Department of Planning and Environment
NSW Government
4 April 2018

**Re: Modification 4 to SSD 5093 - M2 site, North Ryde Station Urban
Activation Precinct**

Scale at A1 1:350	
Discipline Structural	
Job No 234008	Drawing Status Concept
Drawing No S-110	Issue P3

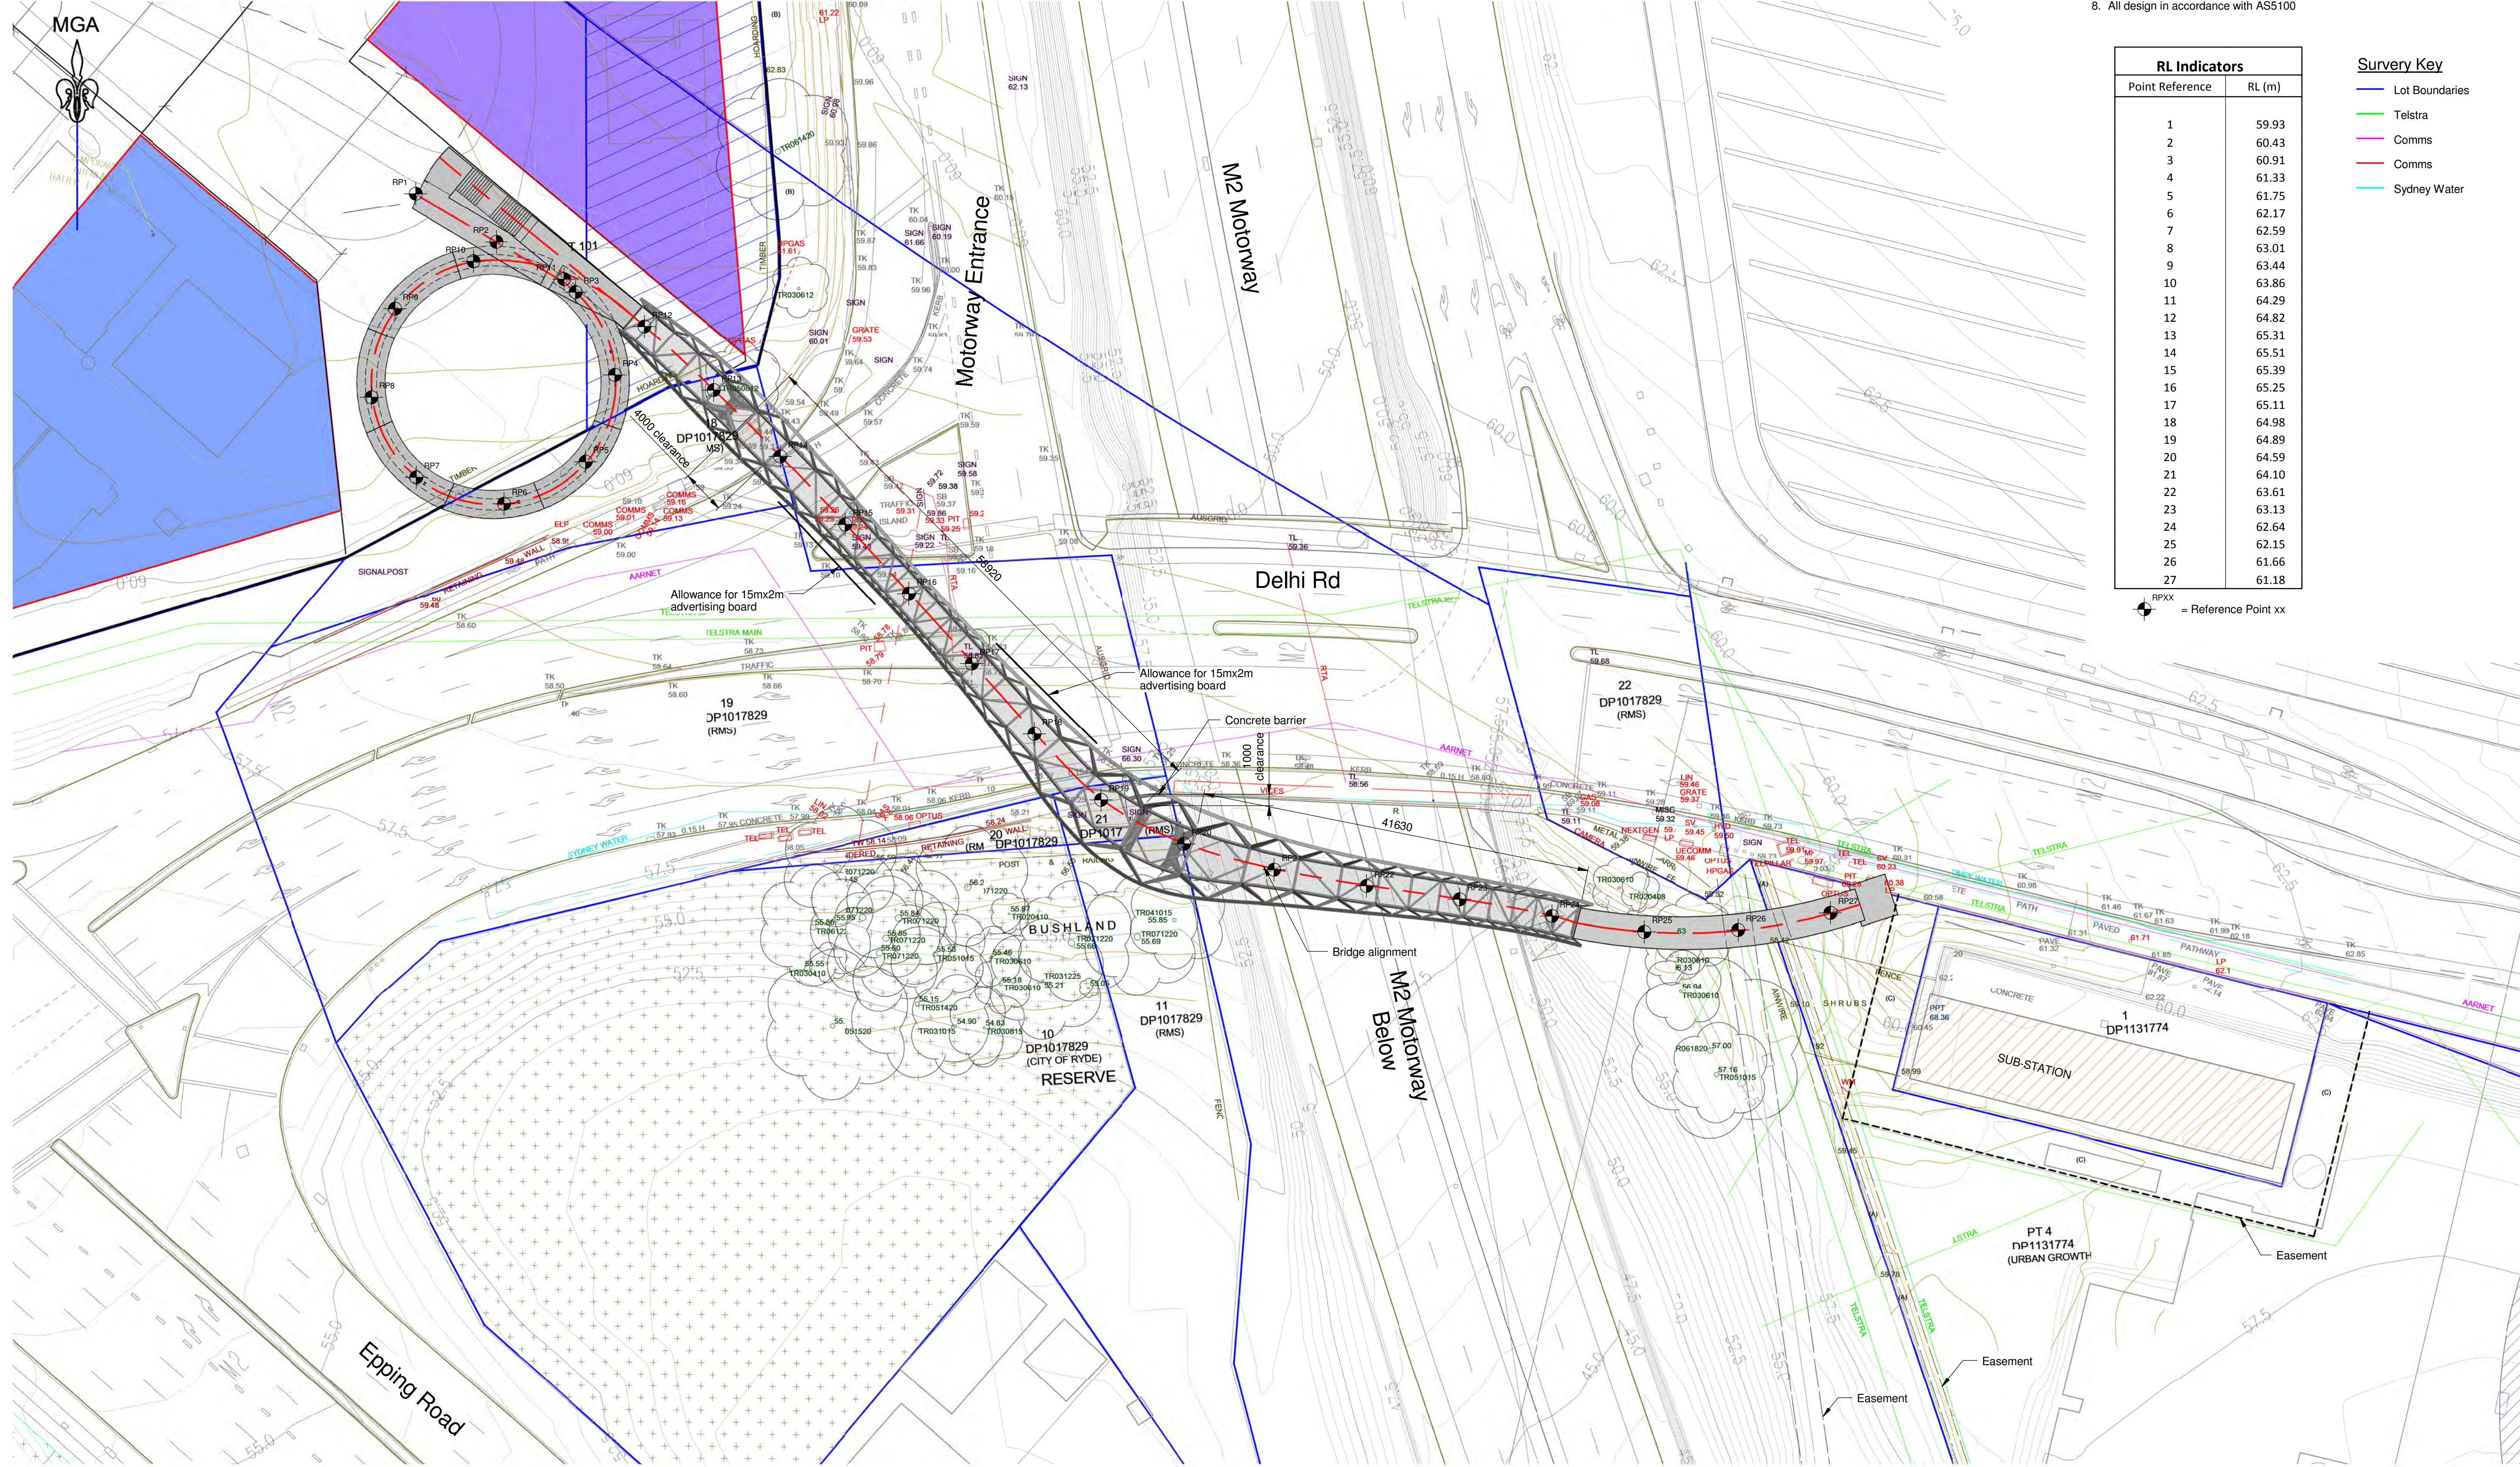
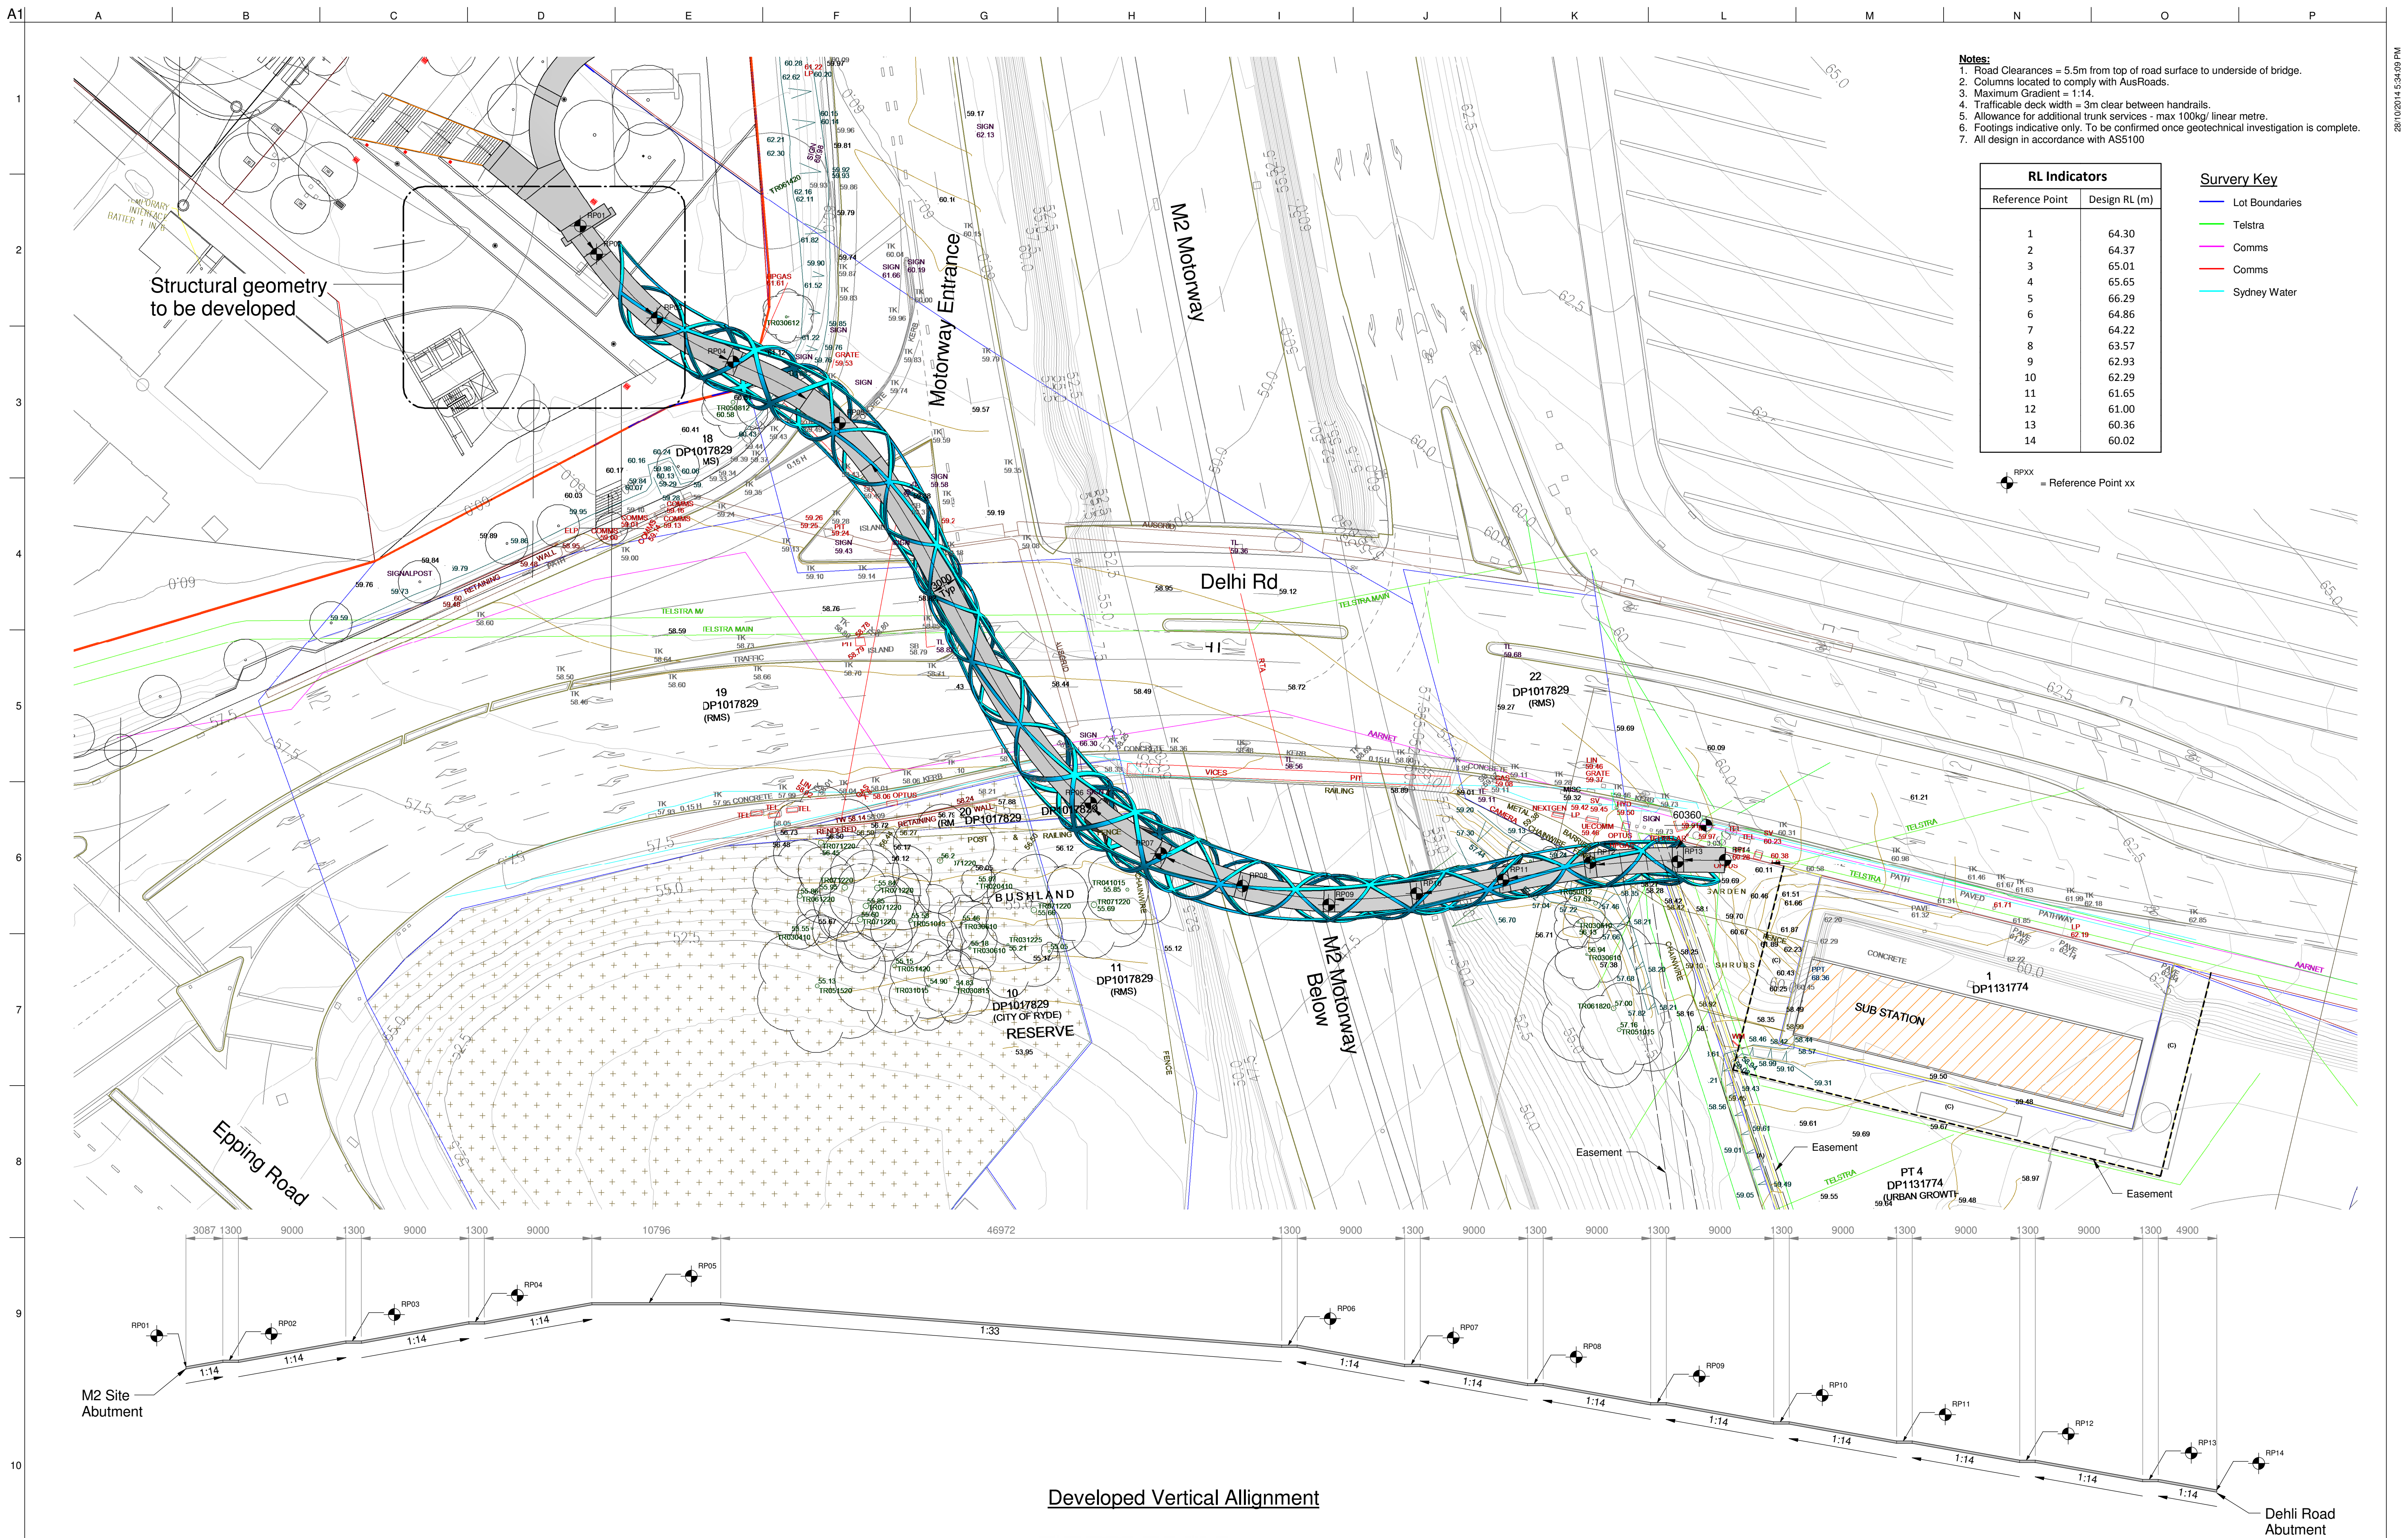
the pedestrian bridge piers on Sydney Turpentine Ironbark Forest. This was in particular relation to pier 2 near Bundara Reserve.¹

Further this now includes complete removal of 450 sq. metres of Sydney Turpentine Forest which is protected under threatened species legislation. Unlike the original approval it is now stated that offsets will be required.

We would argue that this is a substantial change to the original approval. Whilst it is still a pedestrian bridge, the structure is substantially bigger and of a design type it is now claimed necessitates a significant (though unclear) increase in the number of trees to be removed including removal of an area of endangered ecological community.

It is unclear to RHHFFPS how the functional three metre wide bridge discussed during the community consultative phase of the bridge design has morphed into an eight metre spiral with seating at the Bundara corner. None of the significant changes made to the bridge design post exhibition involved public consultation.

5. The proposed bridge pier 2 is not a permitted land use in E2 zoned land under Ryde LEP 2014.
